From: Joanne Lewis <Joanne.Lewis@arun.gov.uk>
Sent: 28 May 2021 07:07
To: Planning.Responses <Planning.Responses@arun.gov.uk>
Subject: RE: Planning Consultation on: BE/80/21/DOC

I refer to the application below to discharge conditions 11 - contamination and 12 - electric vehicle charging.

Application No: BE/80/21/DOC
Registered: 20th May 2021
Site Address: 47 South Way Bersted PO21 5EY
Description of Works: Approval of details reserved by condition imposed under BE/43/20/PL relating to Condition Nos 3 - materials & finishes, 4 - screen walls & fences, 5 - dustbin storage, 7 - covered & secure cycle parking, 9 - site set up during construction, 10 - surface water drainage, 11 - contamination and 12 - electric vehicle charging.

Proposed Replacement Dwellings
at 47 South Way, Bognor Regis
for Mr P Nicol
Drawing P05 May 2021 Scale 1:200 @ A3
Proposed Drawing - Site Plans

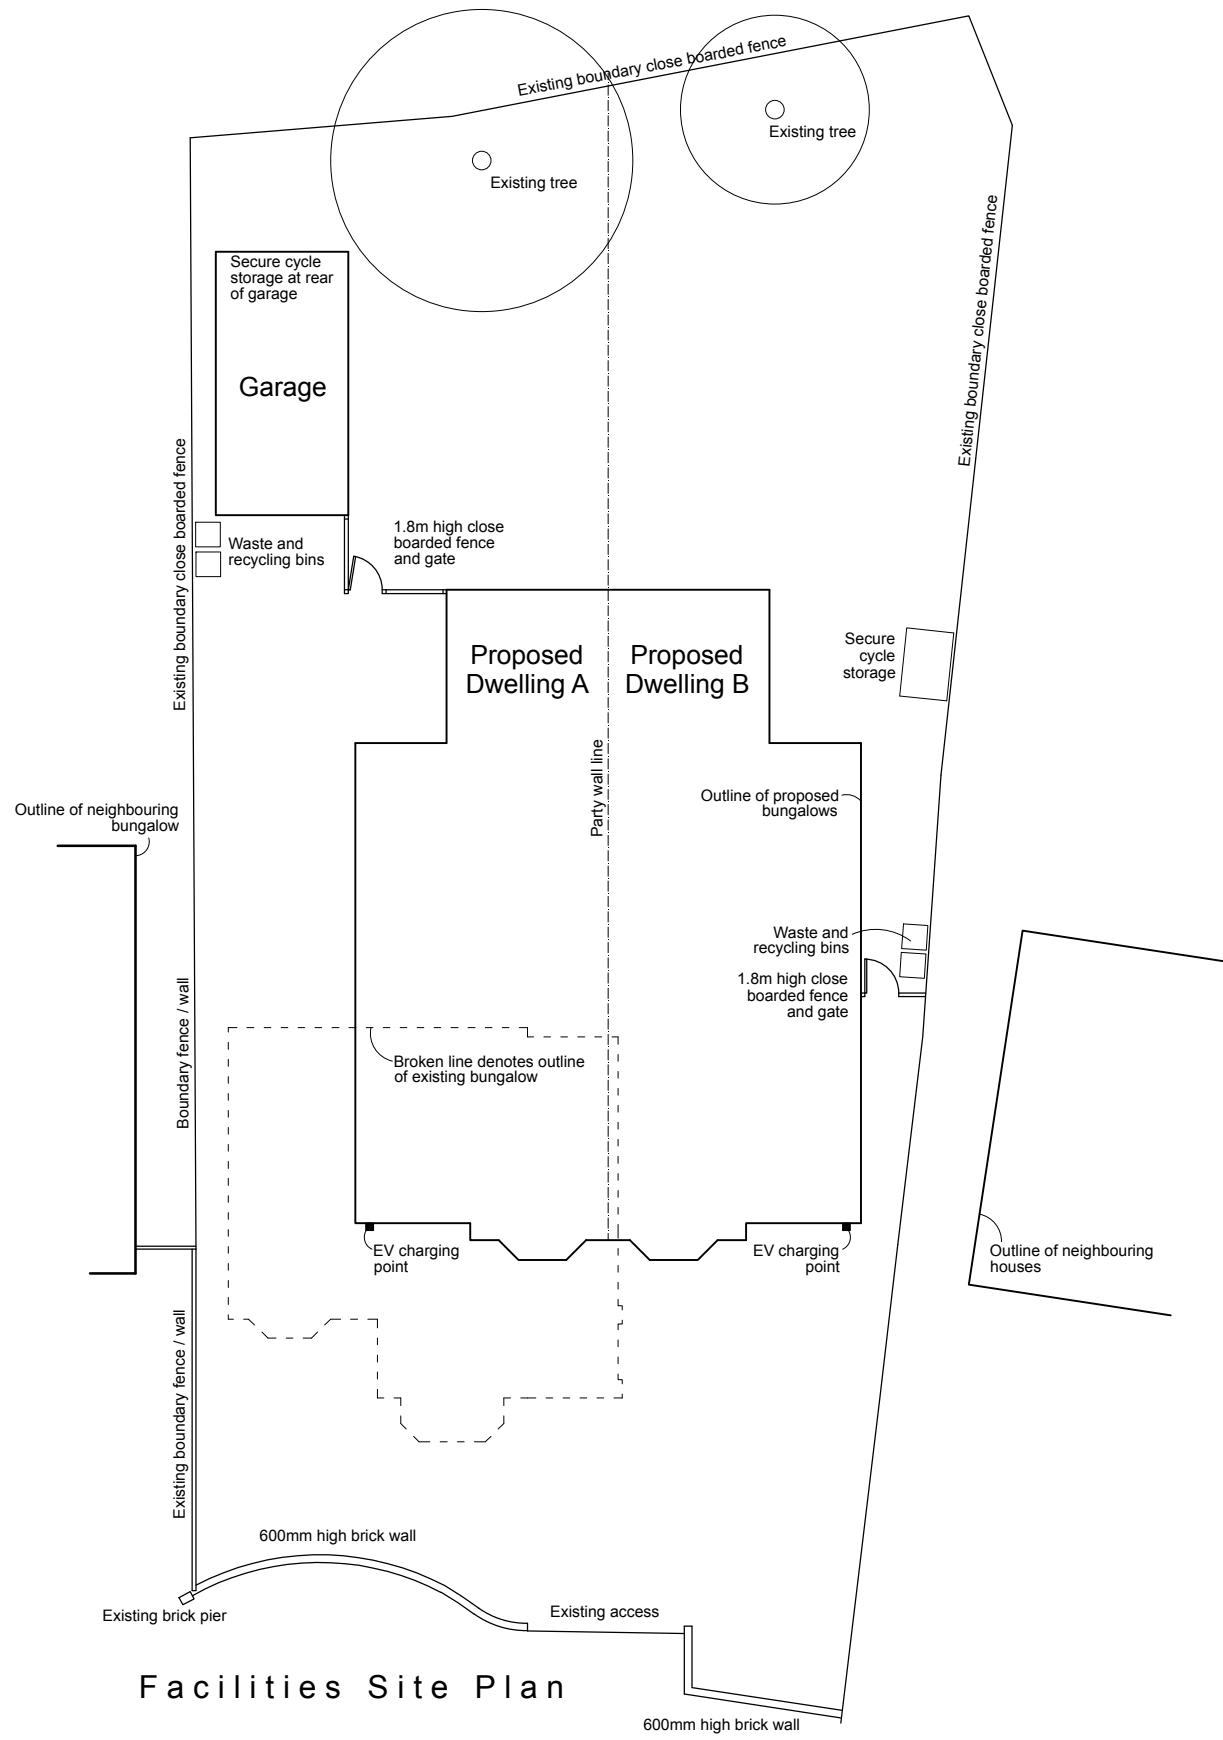
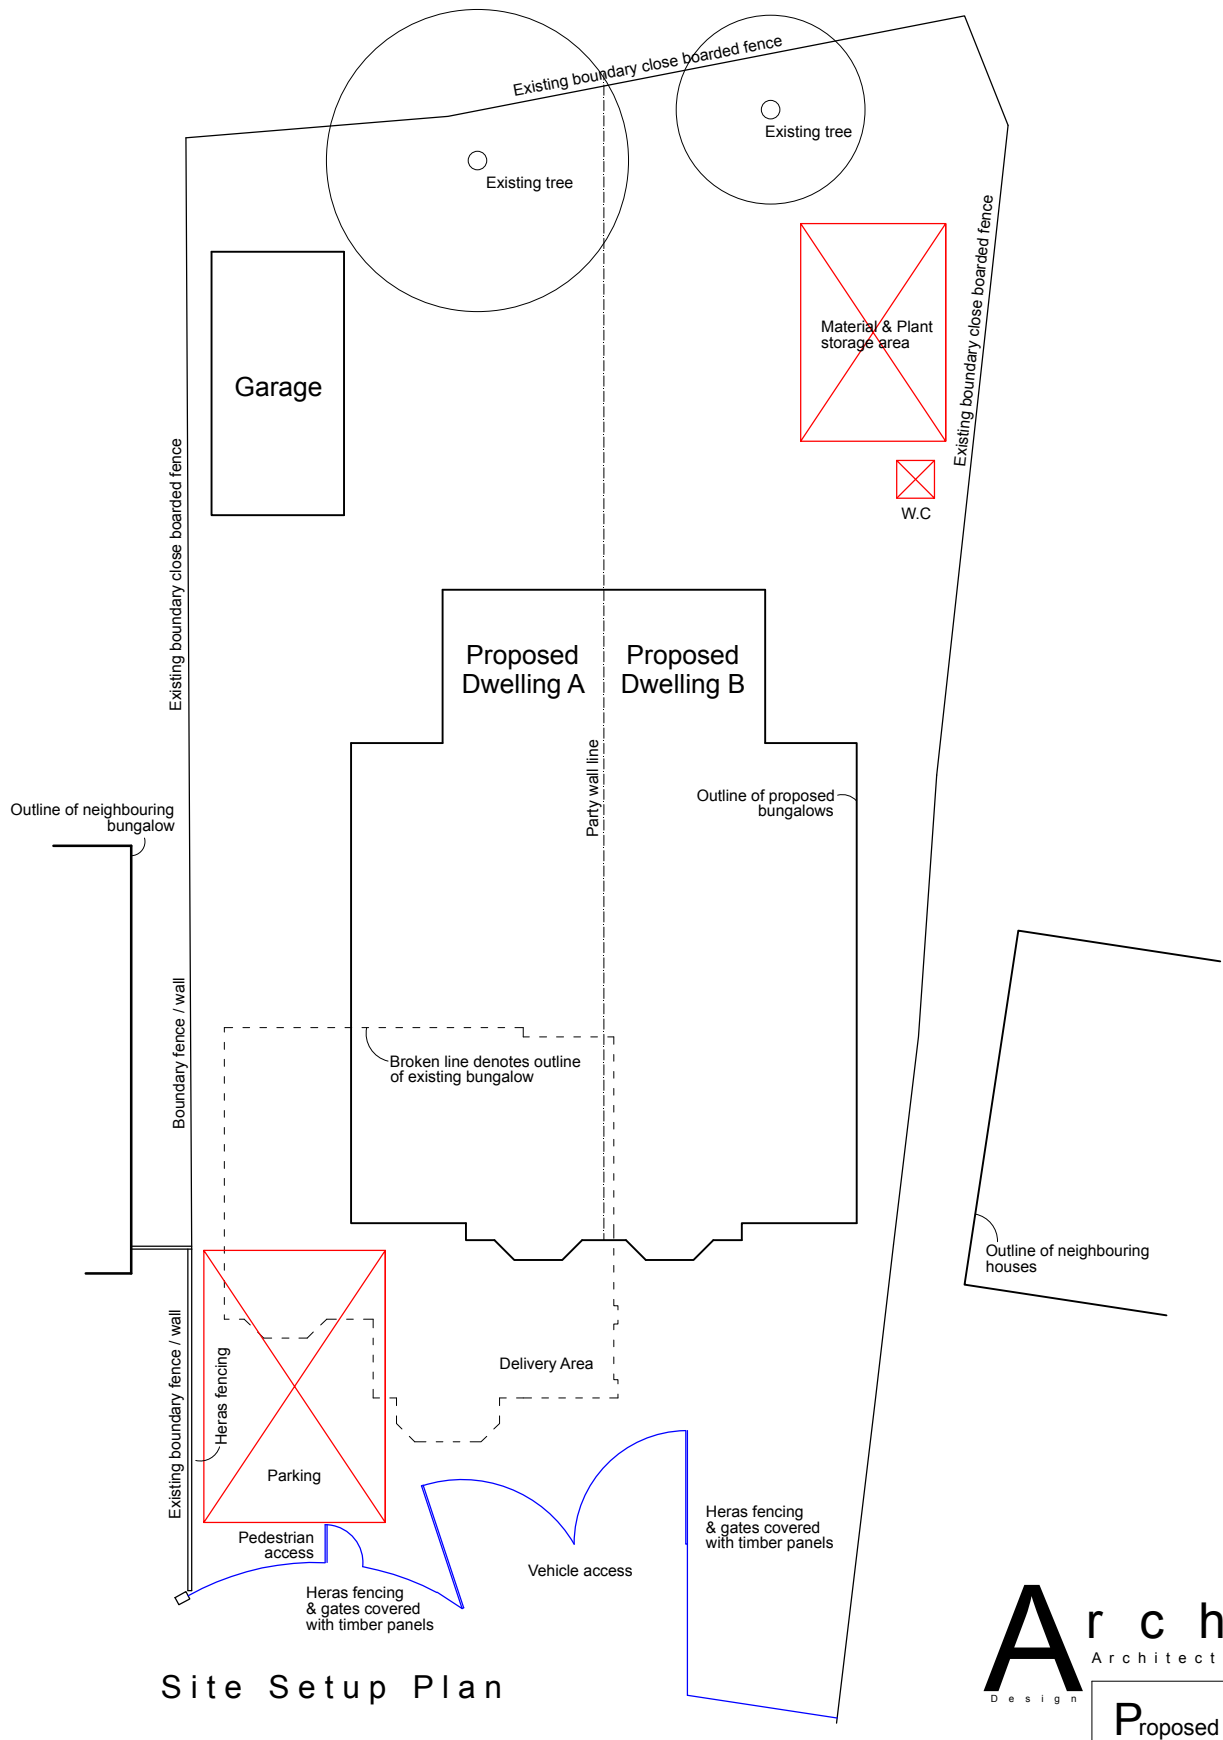
12 - electric vehicle charging – the plan showing the number and location of EV points is acceptable but I can not see that any information on the type of charger to be installed has been submitted and without this I am unable to recommend discharge of this condition. Applicants should note that Environmental Health would be looking for a Mode 3, 7kW fast charger as a minimum.
